Planning Reference P/58/19/PL

I would like to object further to the lack of consideration for the residential amenity of neighbouring properties.

Front Elevation (Units 7)

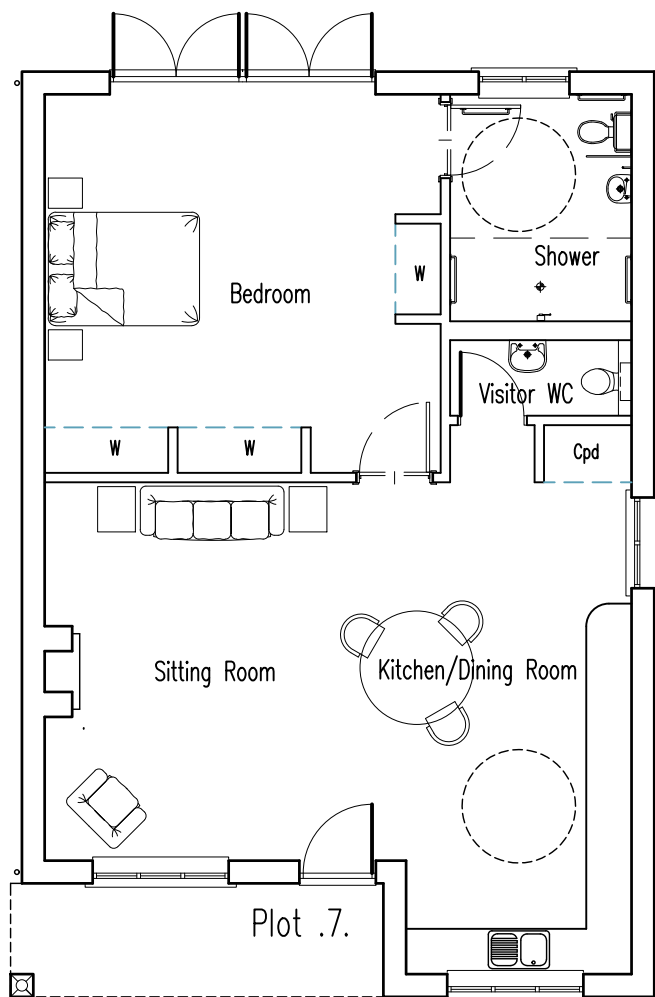
This statement particularly applies to the scale of plot 7 and its proximity to neighbouring properties.

The Planning Statement says that the layout has been amended in line with consultation with neighbours, which was limited, replacing plot 7 from a 2 storey house to a bungalow. This is now a chalet bungalow which has two storeys. I will still be overlooked and suffer overshadowing and loss of daylight to my home and back garden.

No right to light calculation has been carried out, no elevation height is given of the proposed buildings, particularly for plot 7. Without an assessment and using a 'rule of thumb' guide, there should be no development beyond a 45 degree line.
